Re: Letter of Intent Verizon CSP Scarebrook

Verizon Wireless is requesting approval to Co-Locate antennas and equipment on the existing CMRS facility at 17995 Sierra Way, Monument, CO 80132.

SHEET TITLE:  
ELEVATION

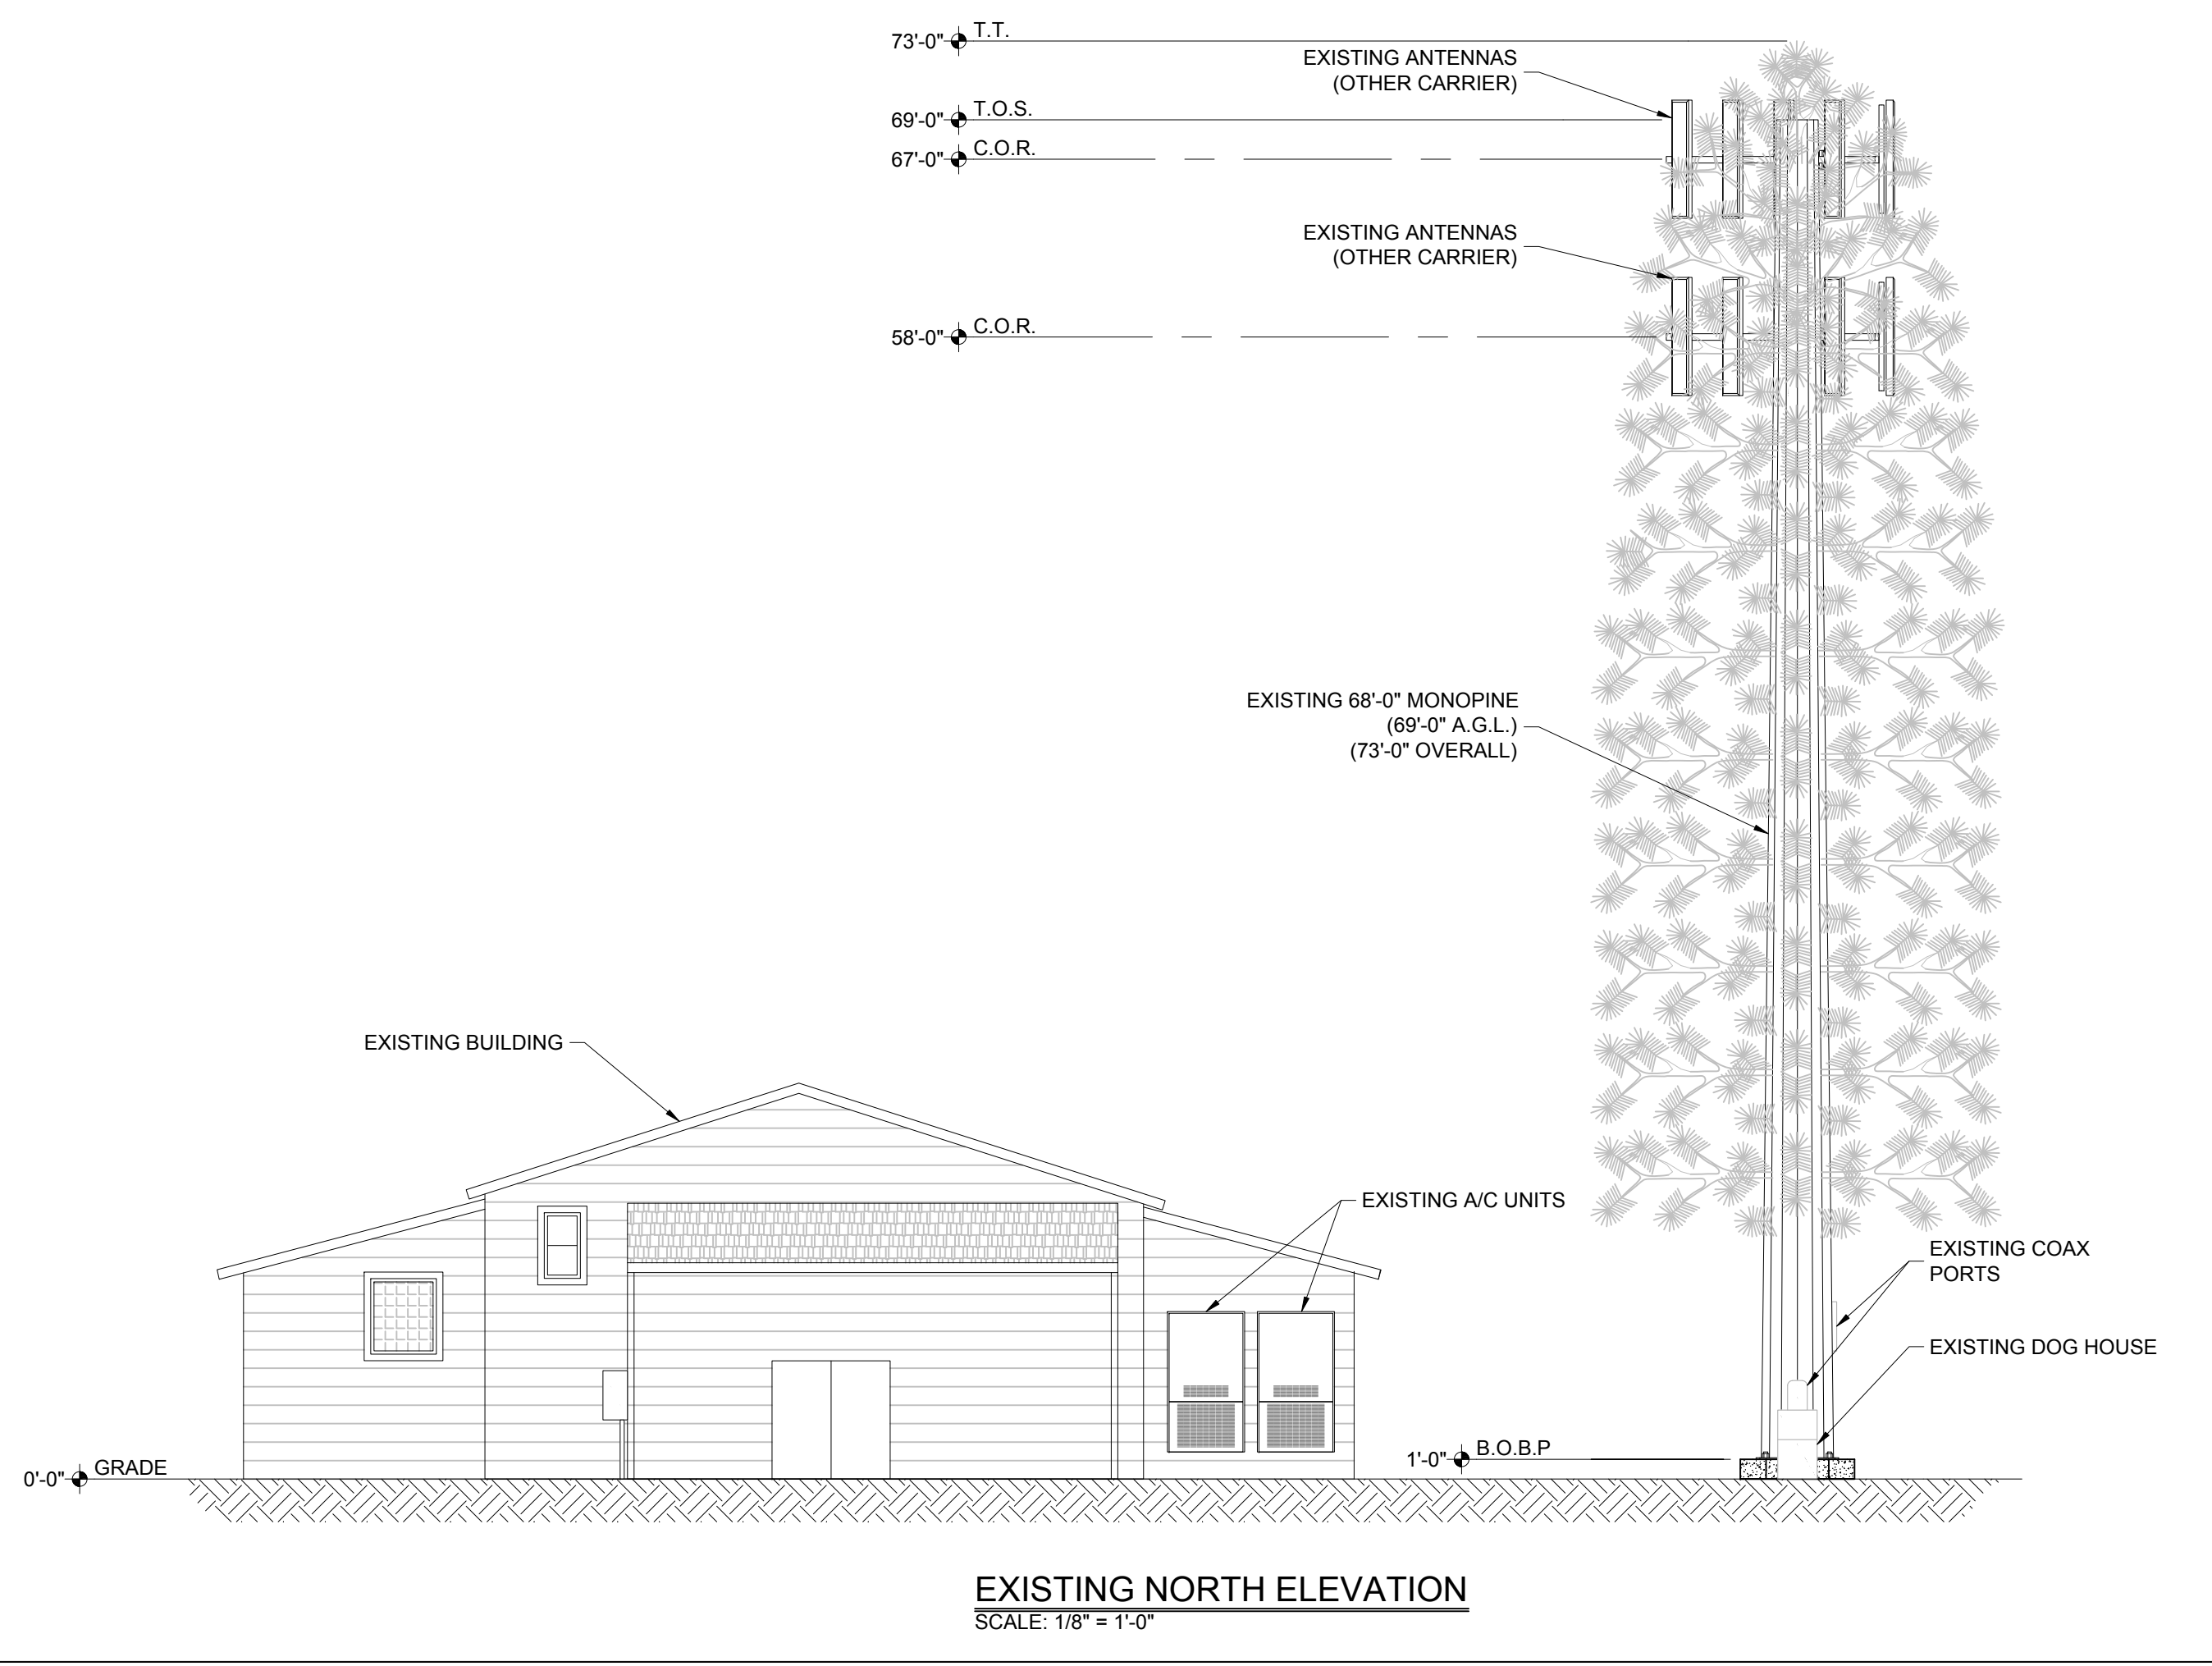
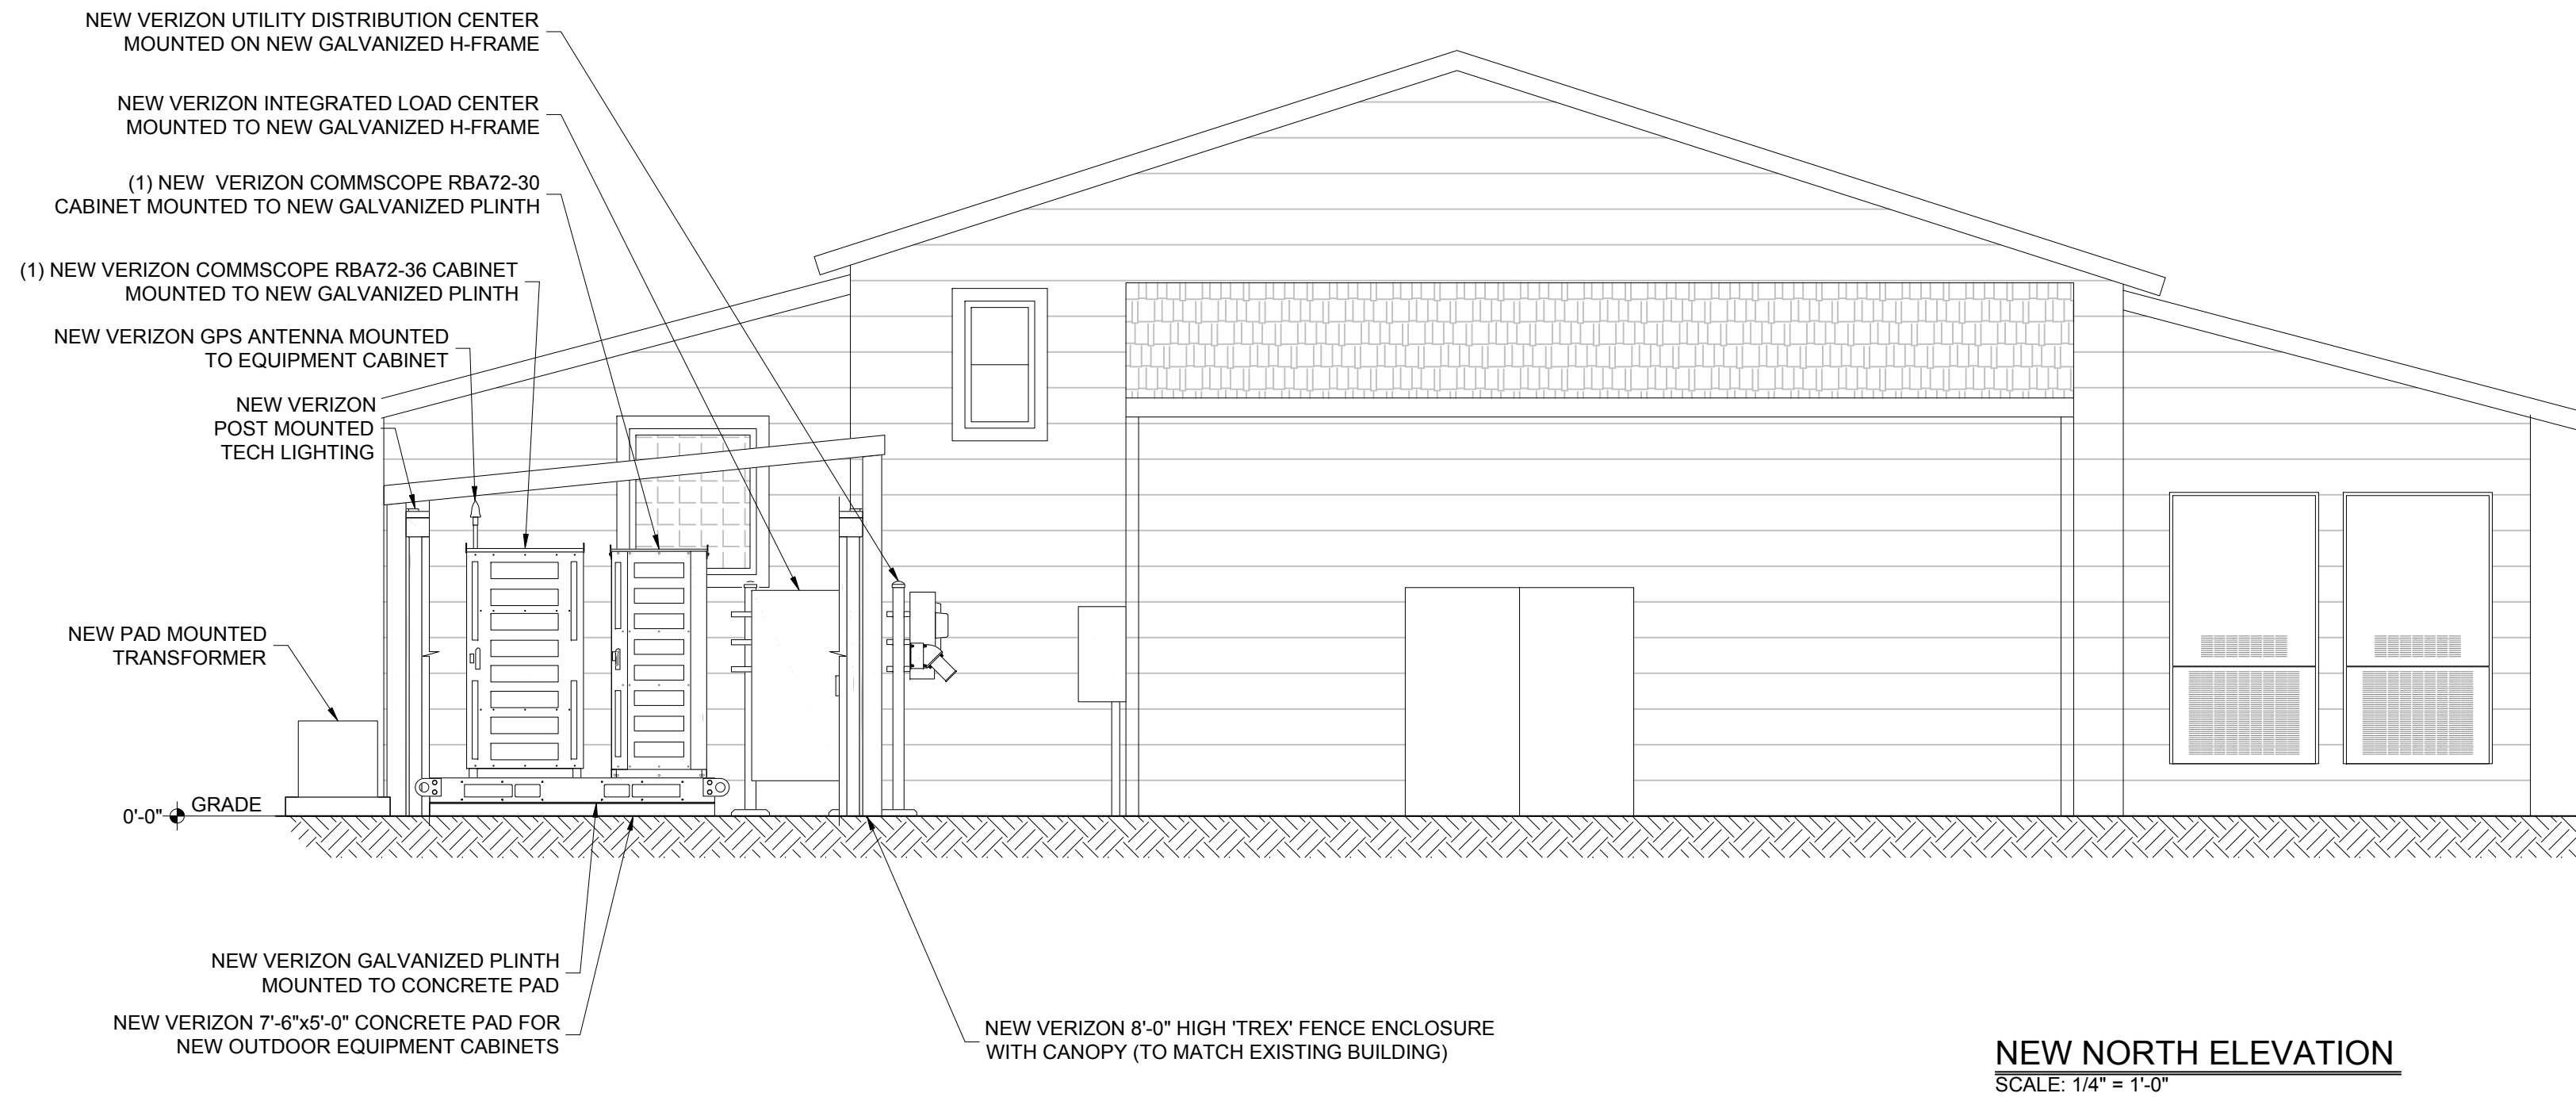
Does this mean it will not extend to 55' or to 80', because in no way is this allowed to go taller than 70 feet.
